From: [Genevieve Sedgwick](#)
To: [Jamey Ayling](#)
Cc: [Mike Read](#); [Juliet Bernitter](#); [Genevieve Sedgwick](#); [Kelley Meister](#); [David Sedgwick](#)
Subject: DV-24-00001 Ranch on Swauk Creek Development Agreement - 30 Day Comment Period
Date: Thursday, July 11, 2024 10:16:11 AM

This is in response to the 30-day comment period regarding the Ranch on Swauk Creek Development Agreement – DV-24-00001

EXHIBIT C

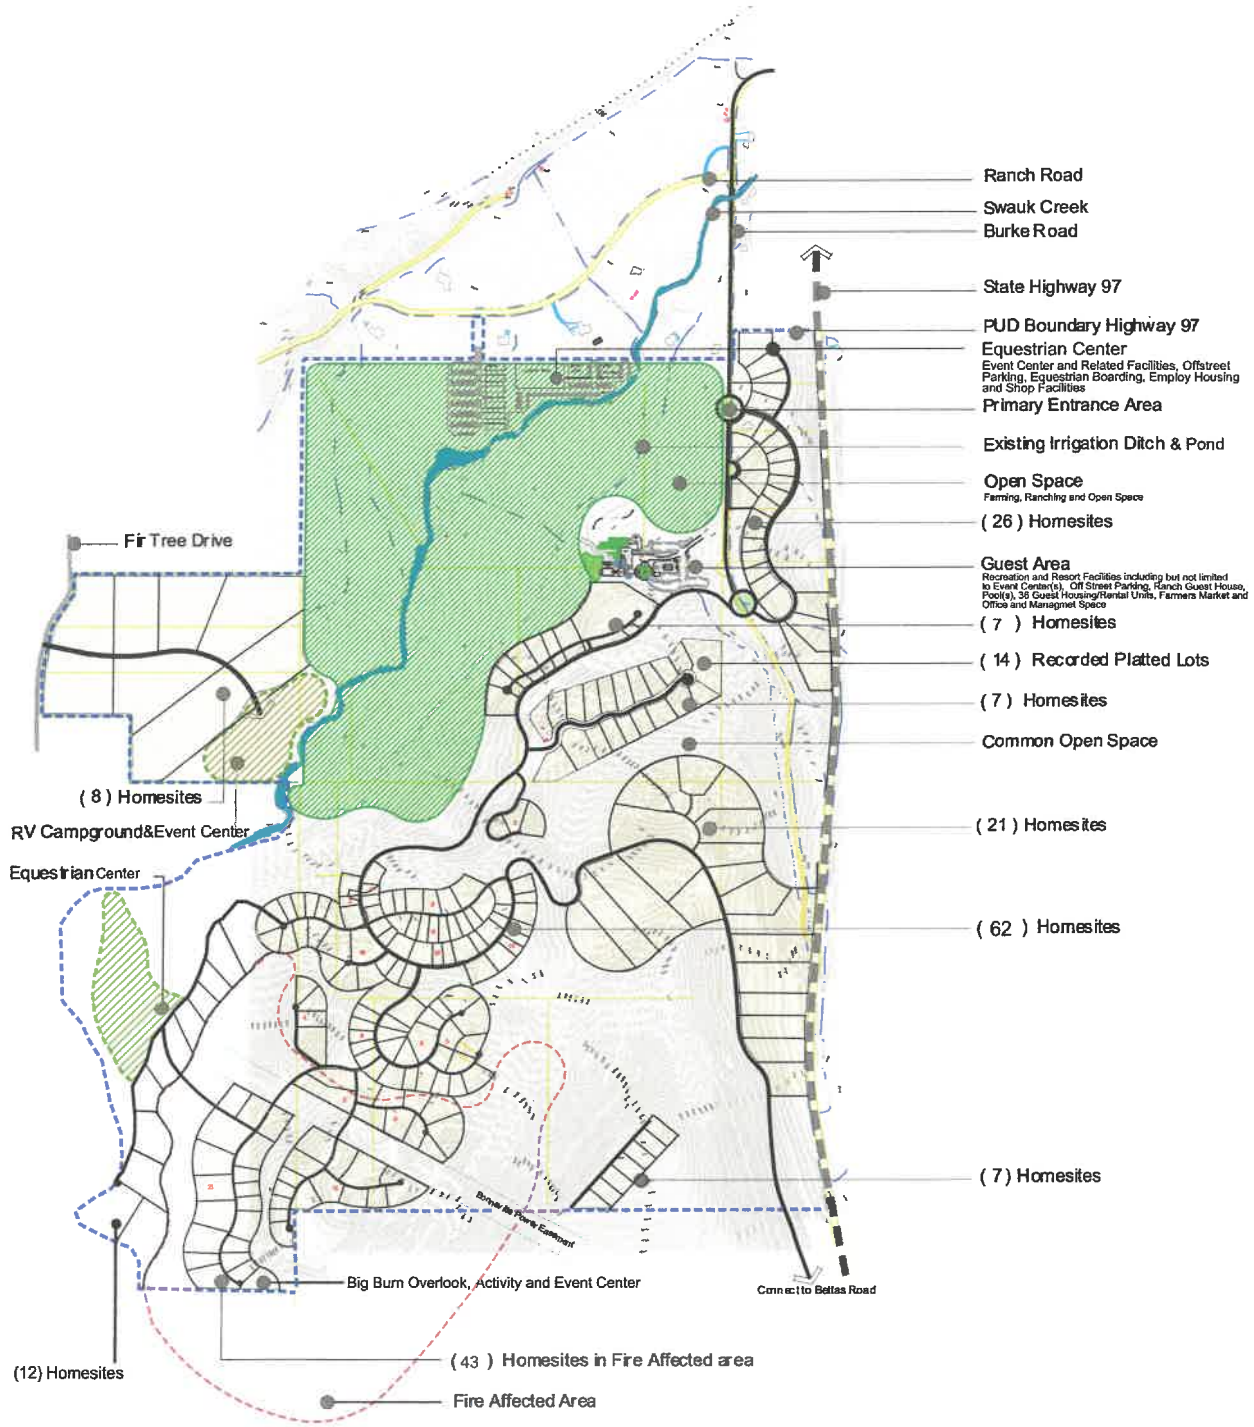
There is no mention of Fir Tree Dr. in the transportation section, but the master plan shows that access will be required for eight lots and the RV Campground & Events Center. Fir Tree is a private road maintained by the Lauderdale Ridge HOA and is not affiliated with ROSC.

The Lauderdale Ridge HOA will not enter into a road agreement with ROSC to access lots to Fir Tree.

Fir Tree has a county road agreement for the number of dwellings today and meets current county road requirements. If there are eight new dwellings, the roads may need significant improvement to meet county road width requirements. This would include widening Fir Tree and removing large trees on private lots. ROSC will need approval from each residence to remove trees; it's unlikely approval will be granted.

Our HOA will soon be a gated community that enters Fir Tree and Mountain Creek Drive. The eight lots will need access to gate codes, which will not be provided.
